Date: 23rd October 2019

OBJECTION

State Significant Development Application No: SSD-10300

Coffs Harbour Cultural and Civic Space

GORDON ST ELEVATION

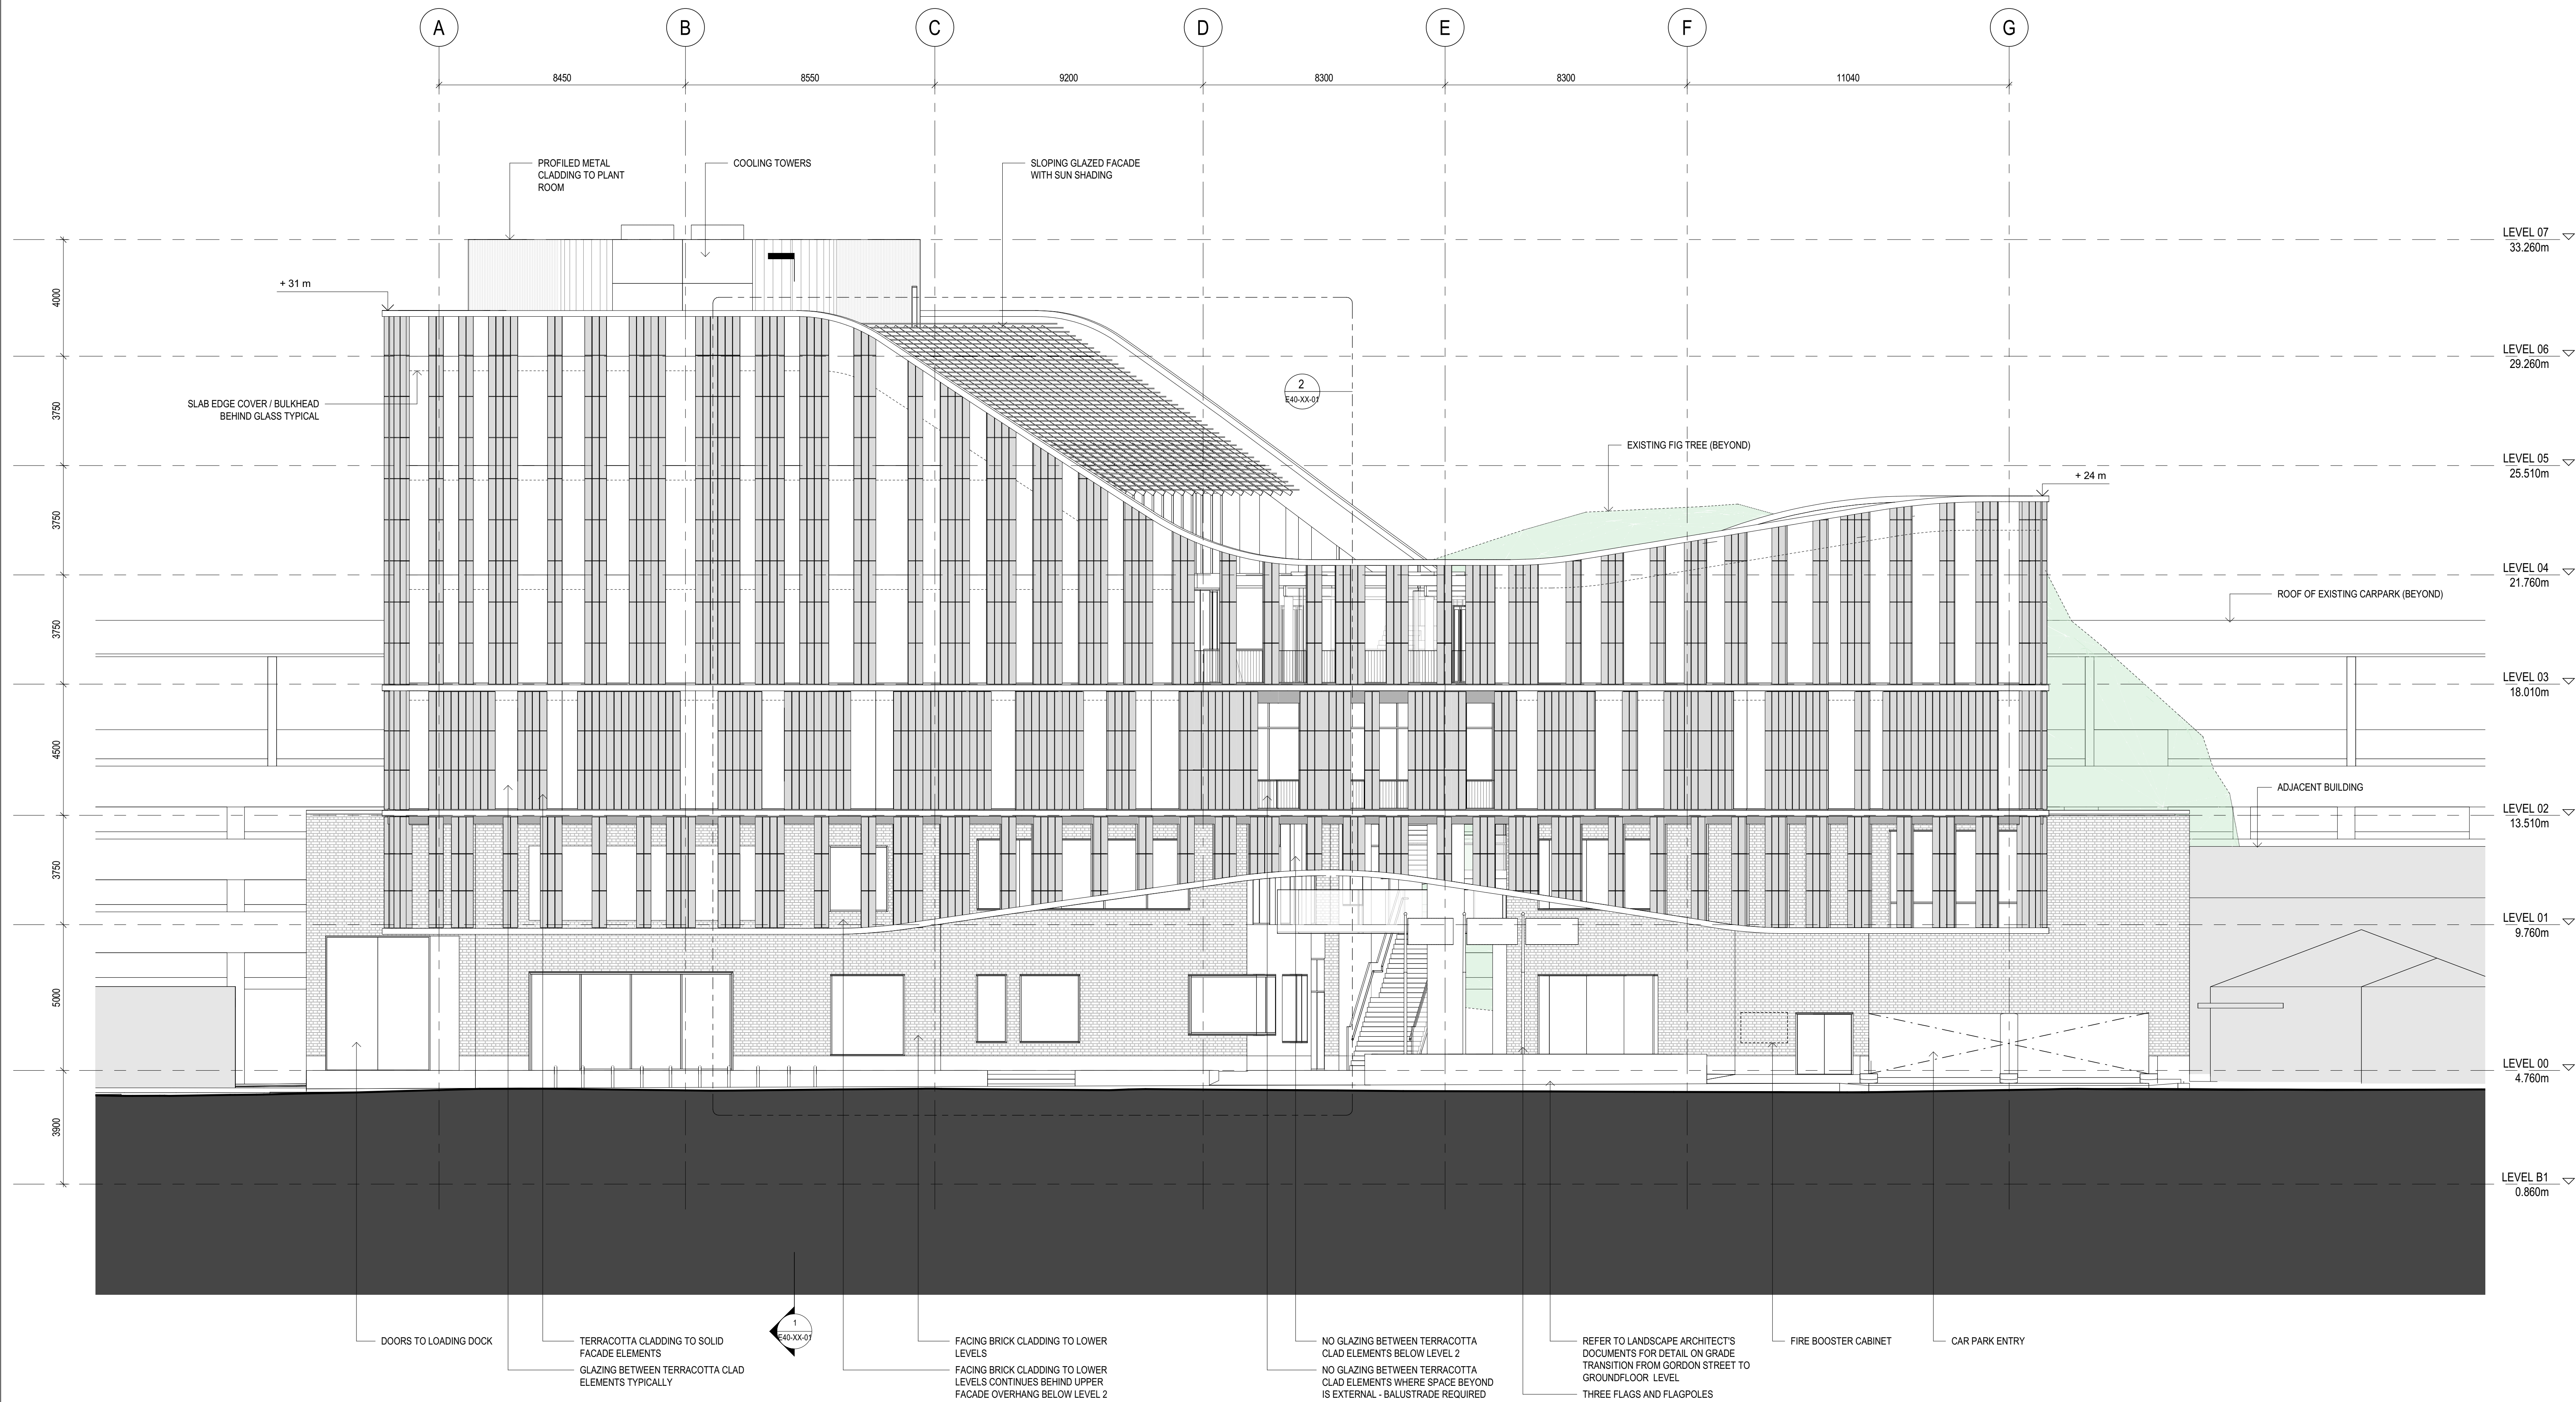
5. The proposed building is out of context in the street with no regard to scale, existing street setbacks, design and general form of adjoining buildings.

SECTION N-S

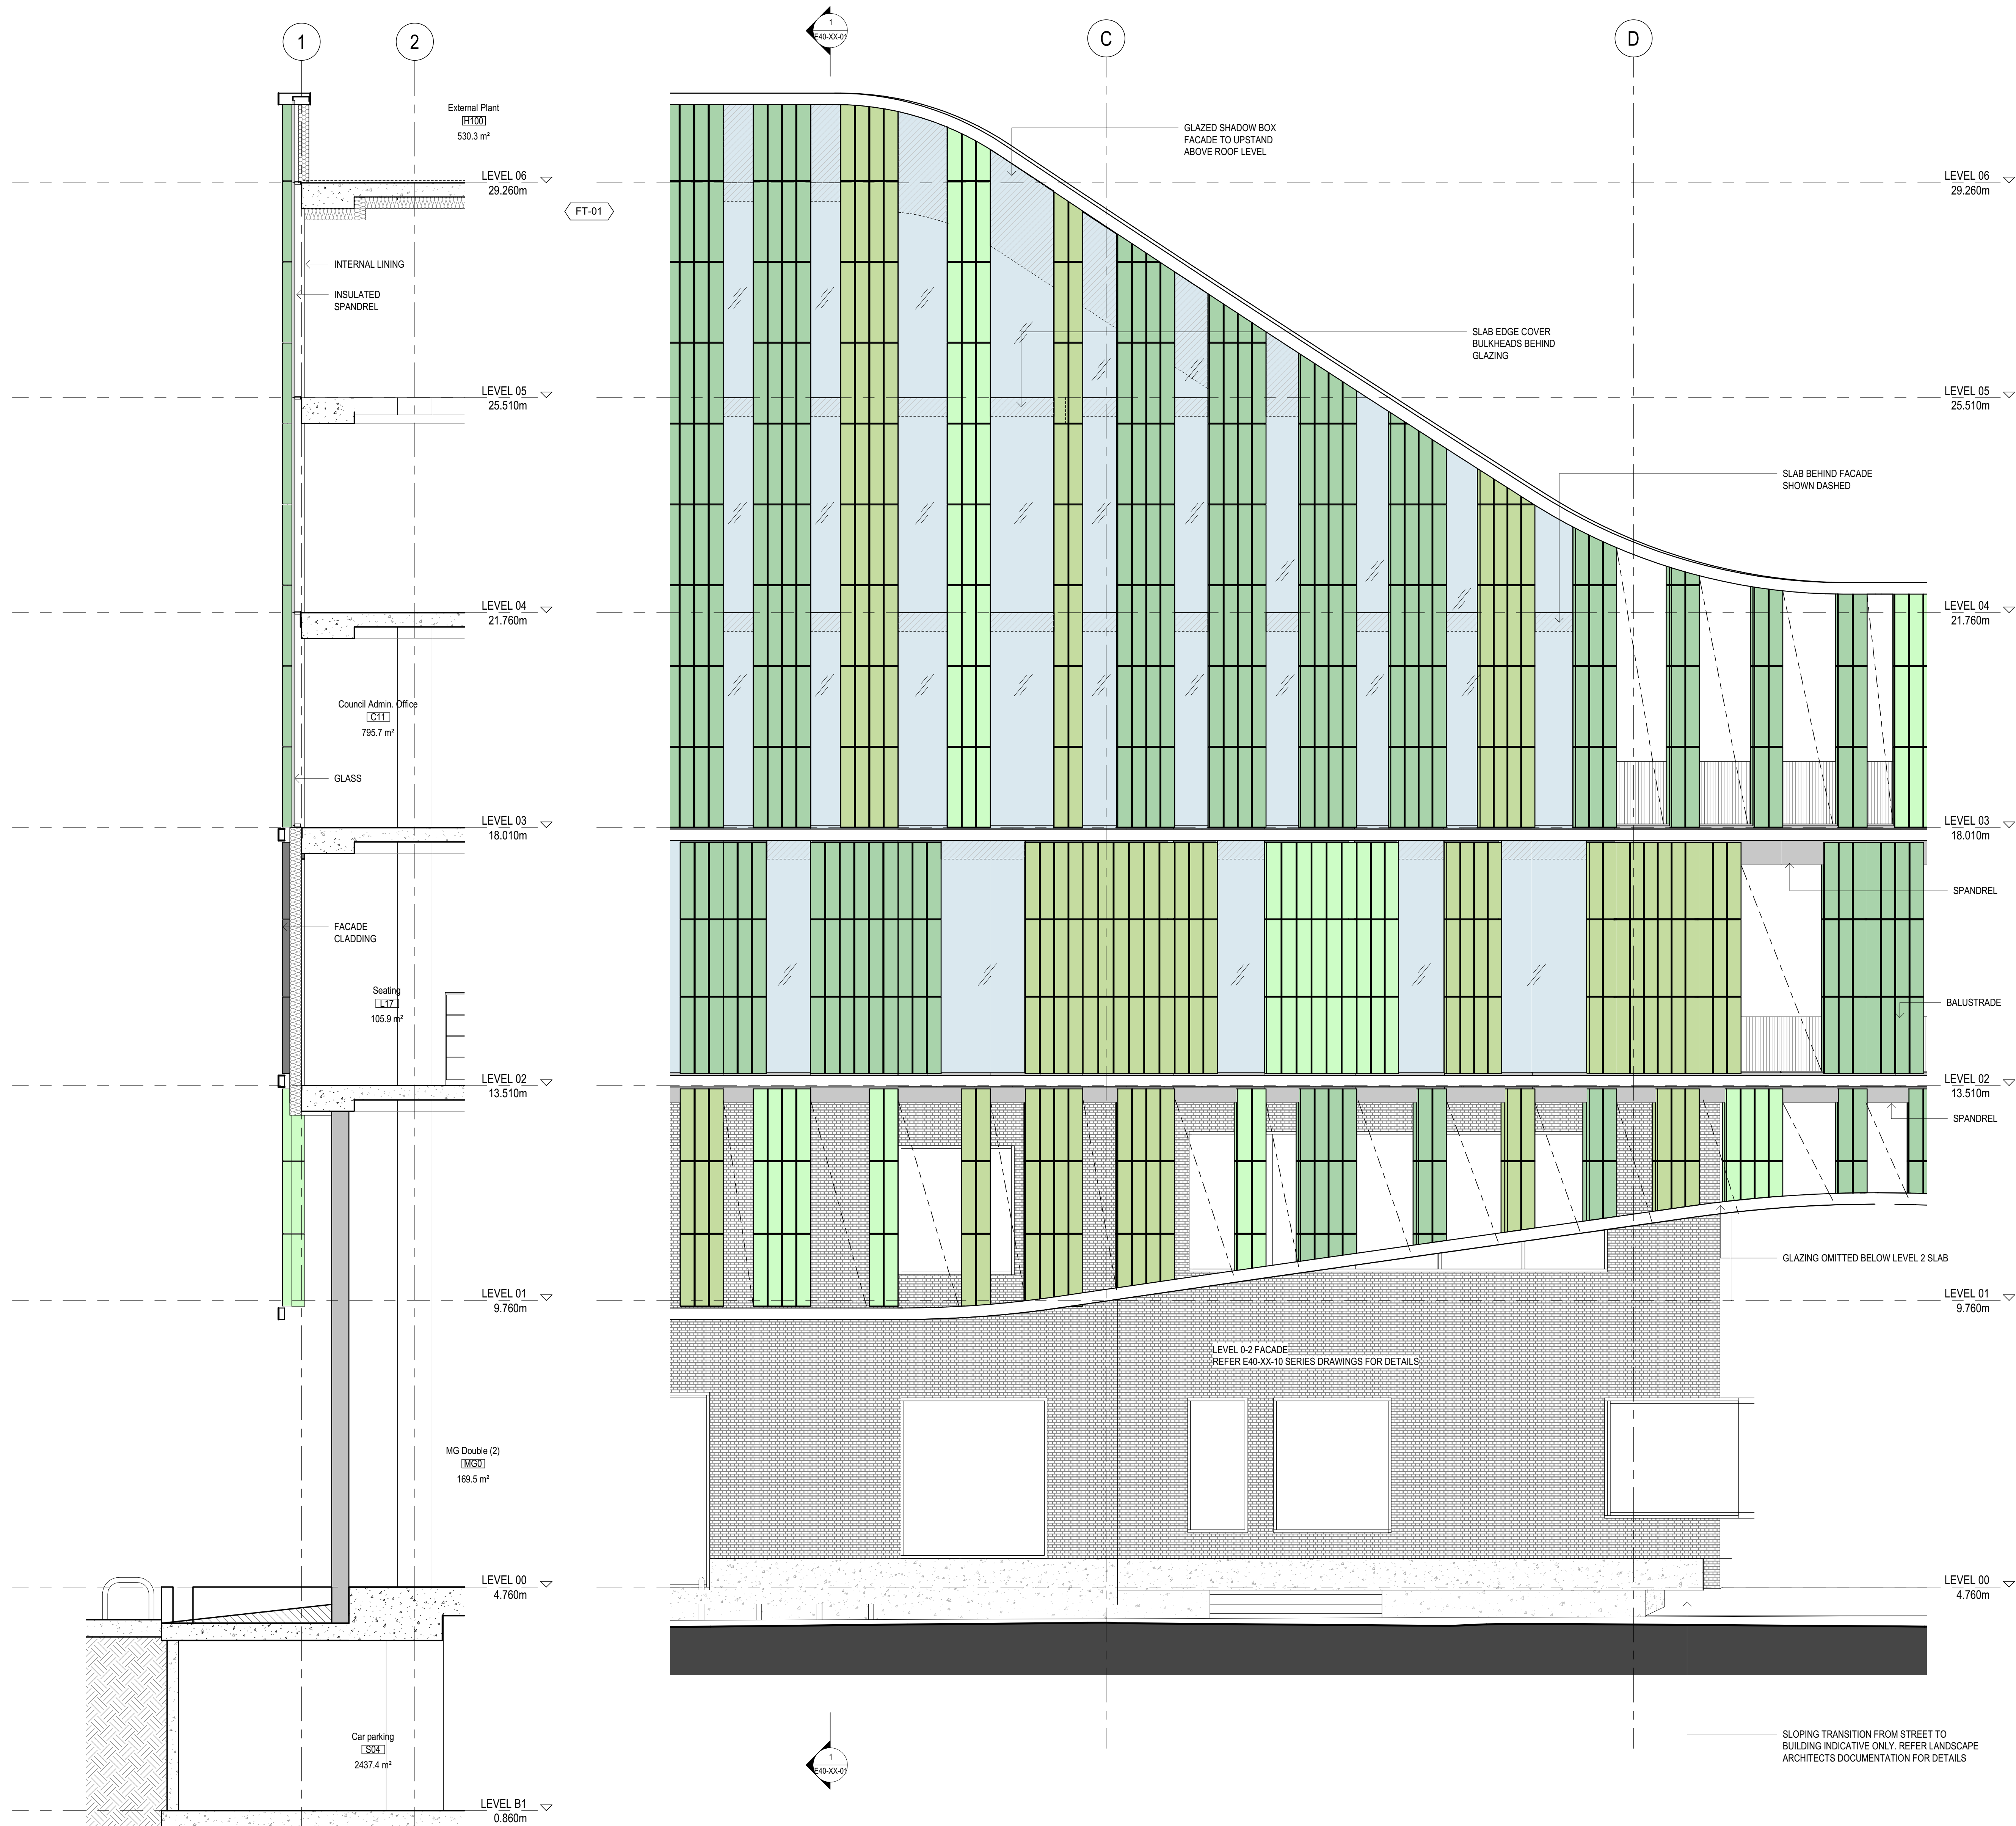
7. As a public building it fails to provide sufficient climate protection for pedestrians during storms and summer sun.
8. The building exceeds the height restriction of 28m set down in Council's own planning controls. Council's argument for variation is not satisfactorily justified and is not consistent with the objectives of the Environmental Planning and Assessment Act 1979, which requires the "the orderly and economic use and development of land". Council should not receive preferential treatment.
